**From:** TownPlanning LNW [mailto:TownPlanningLNW@networkrail.co.uk]  
**Sent:** 24 October 2016 13:28  
**To:** planning  
**Subject:** Ribble Valley ref 3-2016-0711 9 Downham Road Chatburn 2 dwellings

3/2016/0711  
9 Downham Road, Chatburn  
Two detached dwellings and conversion of an existing building to workshop and annex  
376969 / 444071

TYPICAL FENCE DETAIL - 1:50

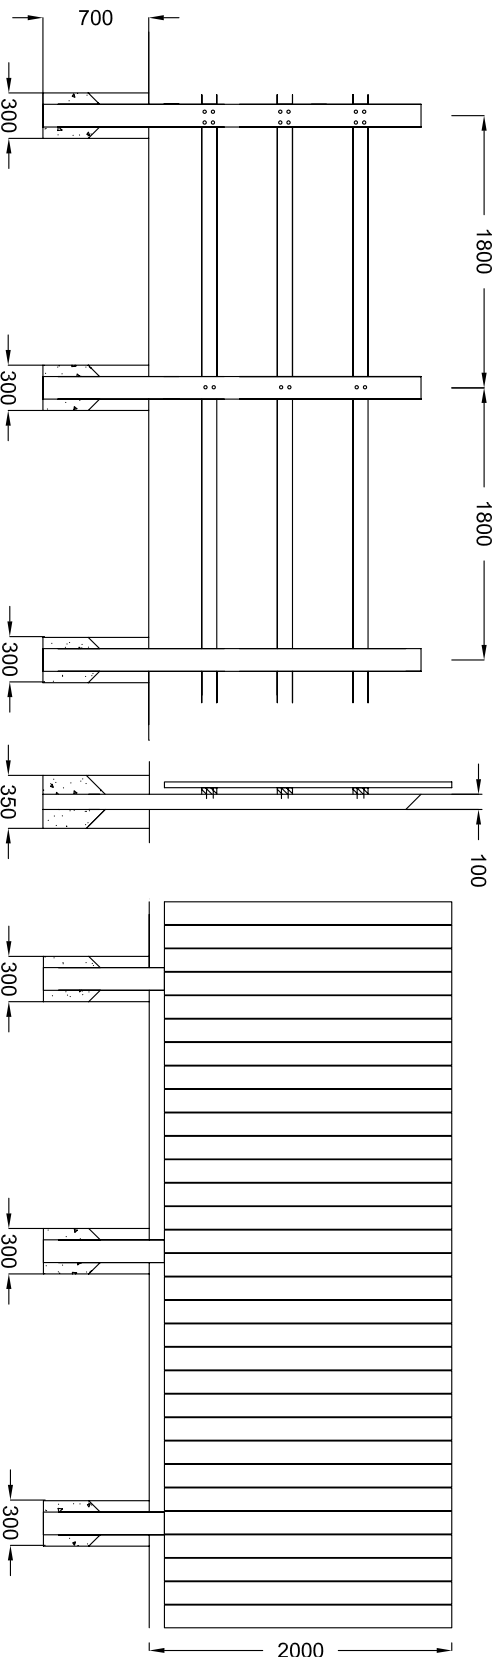
Acoustic fencing / close boarded fencing that is proposed to be installed along the boundary with Network Rail is a cause for concern. Therefore the acoustic fence and its foundation design would be subject to the Network Rail Asset Protection Engineer review and agreement.

Over the height of 1.8m, Network Rail would have to consider the impacts of wind loading on the fence. There is the potential for the fence to topple over and fall onto or towards the operational railway and damage Network Rail's existing boundary treatments, safety critical lineside equipment and cable degradation. De-stabilisation of land, soil slippage and railway fencing foundations being undermined should also be considered as potential areas impacted by a high acoustic fence. Network Rail's existing fencing must remain in place. The applicant's close boarded fence must not be attached to any Network Rail land or infrastructure and must be supported and constructed wholly within the applicant's land ownership footprint including any foundations which must not encroach under, over or on the railway boundary.
